**MISSENDEN ROAD, CAMPERDOWN
CHRIS O'BRIEN LIFEHOUSE, ROYAL PRINCE ALFRED HOSPITAL - ENVIRONMENTAL
ASSESSMENT**

Reference is made to the Department of Planning's correspondence dated 6 August 2010 regarding the subject Environmental Assessment (EA) forwarded to the Roads and Traffic Authority (RTA) for comment.

The RTA has reviewed the subject EA and provides the following comments to the Department of Planning for its consideration in the determination of the application:

BASEMENT PLANS
BASEMENT 1

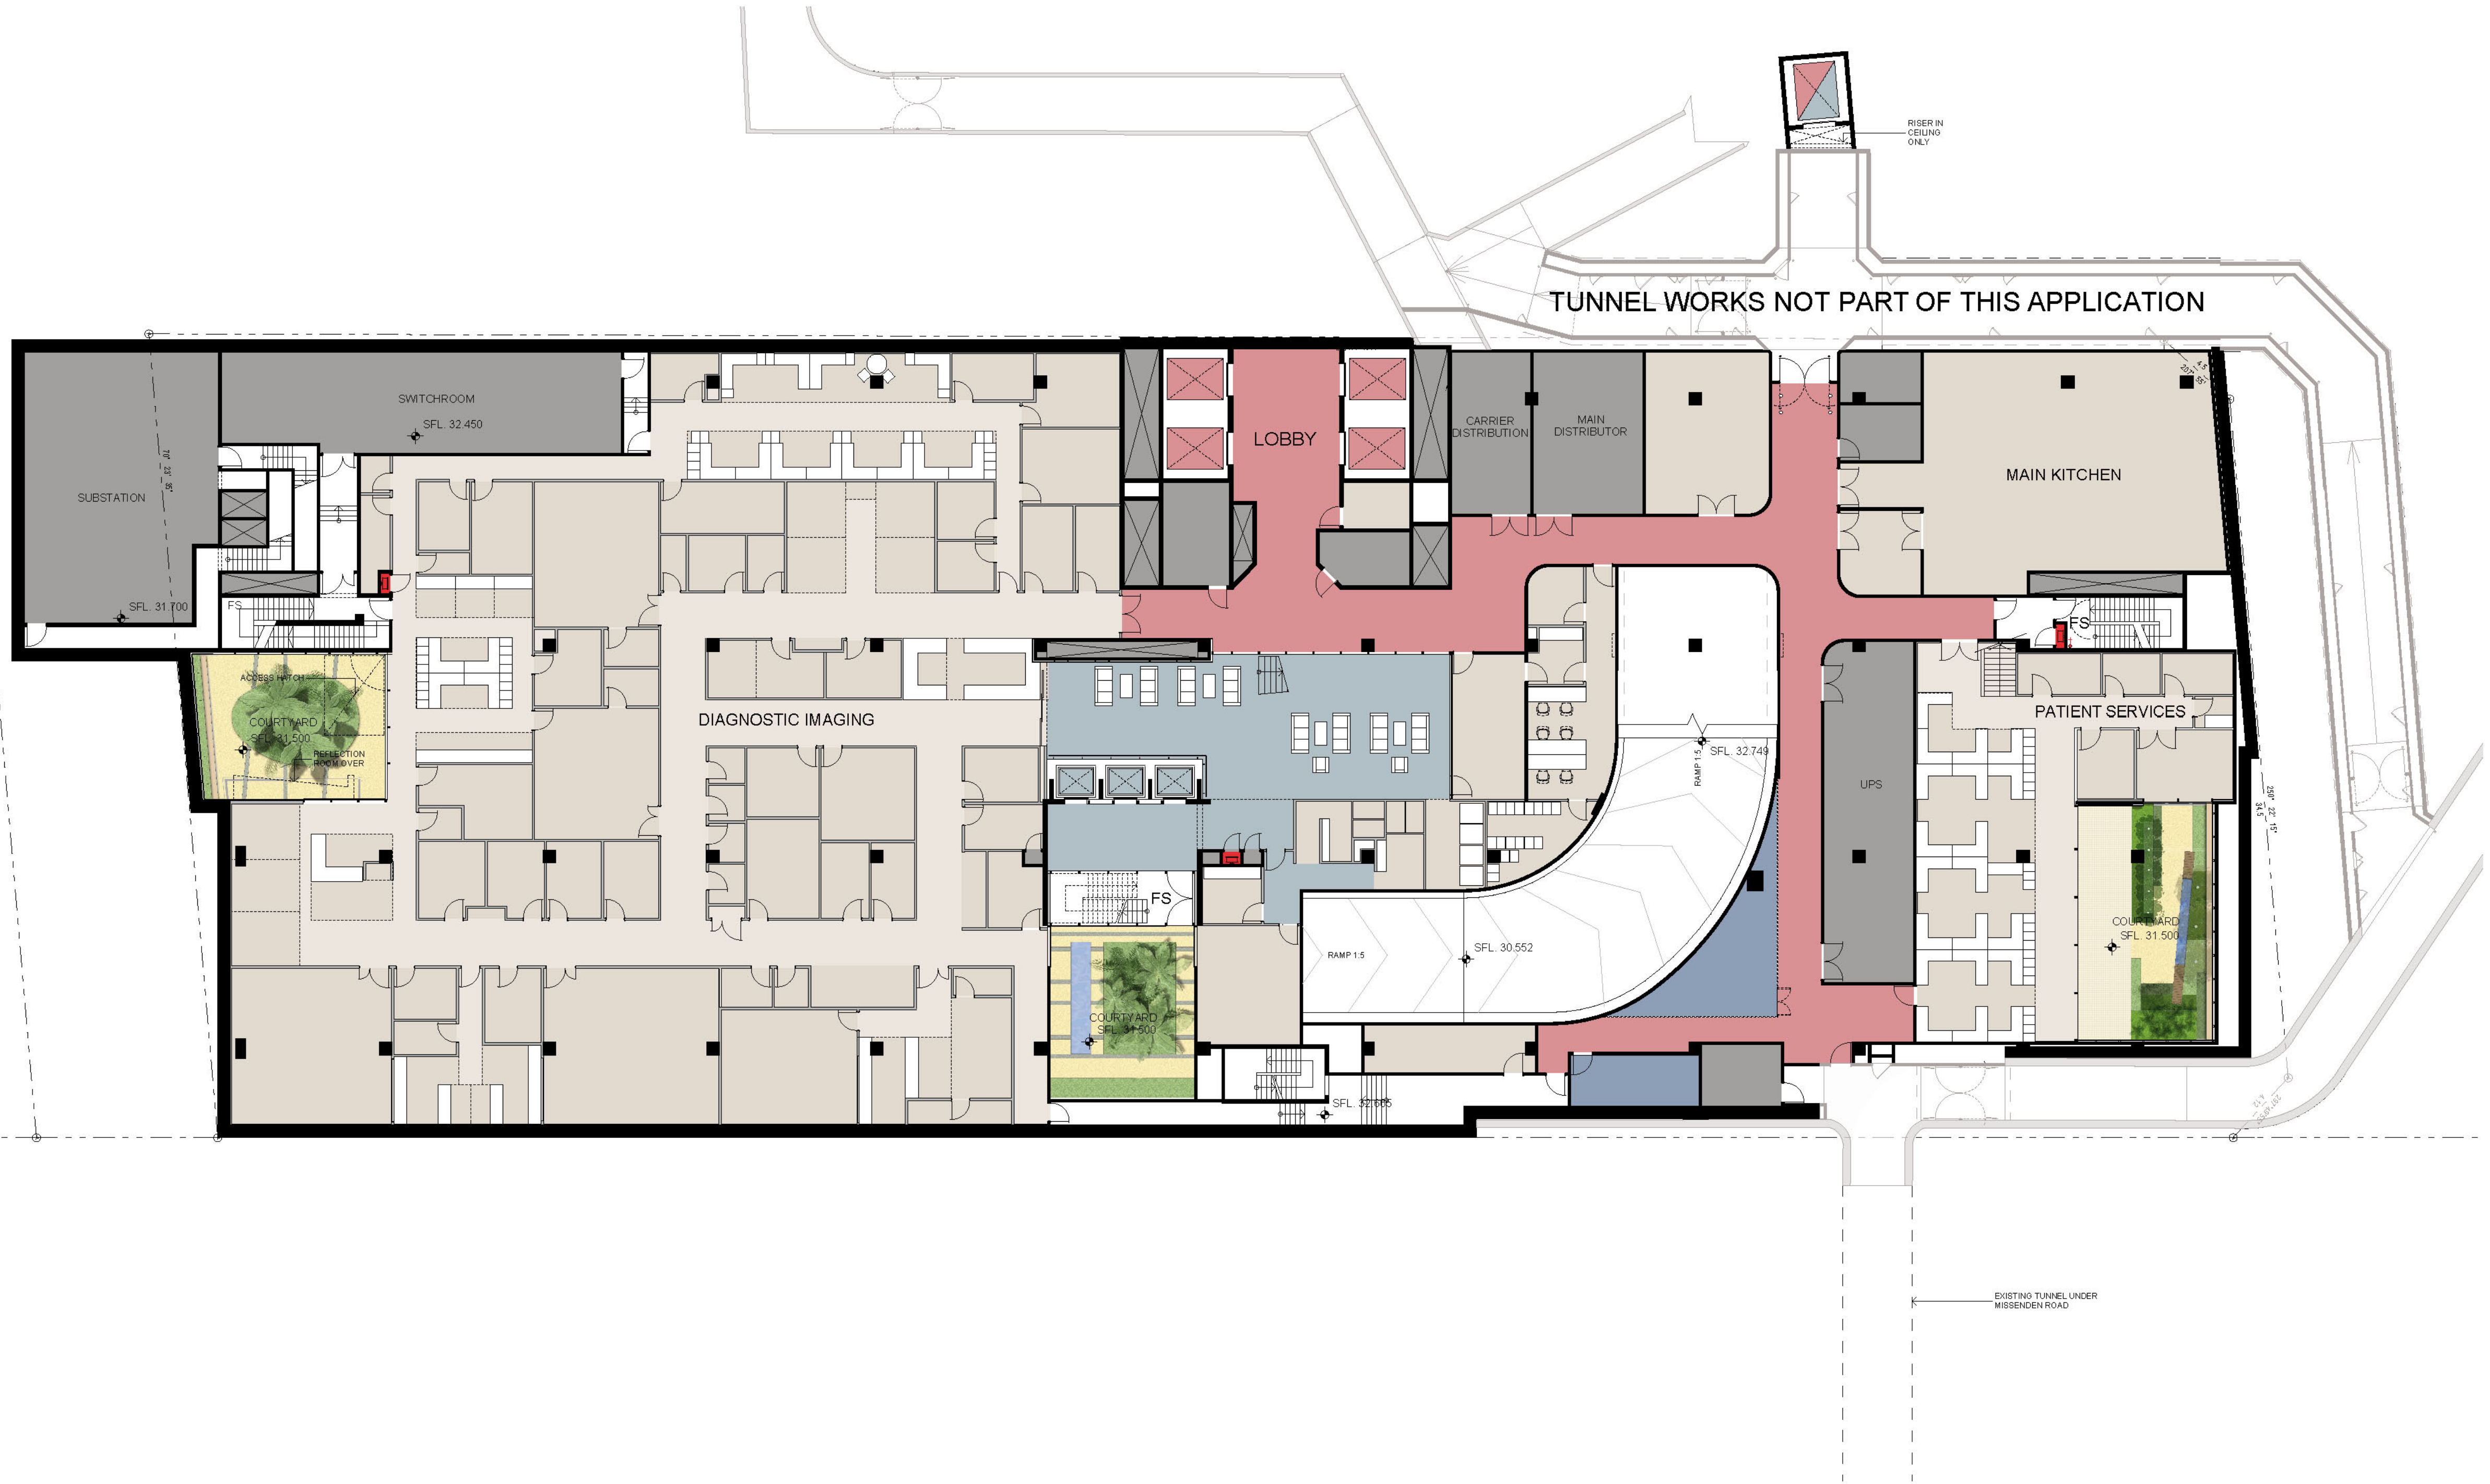
3. The proposed development will generate additional pedestrian movements in the area. Consideration should be given to ensuring pedestrian safety.
4. Clear sight lines shall be provided at the property boundary line to ensure adequate visibility between vehicles leaving the car park and pedestrians along the frontage road footpath in accordance with Figure 3.3 of AS 2890.1 - 2004 for light vehicles and AS 2890.2 - 2002 for heavy vehicles.

5. The layout of the proposed car parking areas associated with the subject development (including, driveways, grades, turn paths, sight distance requirements, aisle widths, aisle lengths, and parking bay dimensions) should be in accordance with AS 2890.1- 2004 and AS 2890.2 – 2002 for heavy vehicle usage.

6. The swept path of the longest vehicle (including garbage trucks) entering and exiting the subject site, as well as manoeuvrability through the site, shall be in accordance with AUSTROADS. In this regard, a swept path plan shall be submitted to the Department of Planning for approval, which illustrates that the proposed development complies with this requirement.

7. The proposed turning areas within the car park are to be kept clear of any obstacles, including parked cars, at all times.
8. All vehicles are to enter and leave the site in a forward direction.
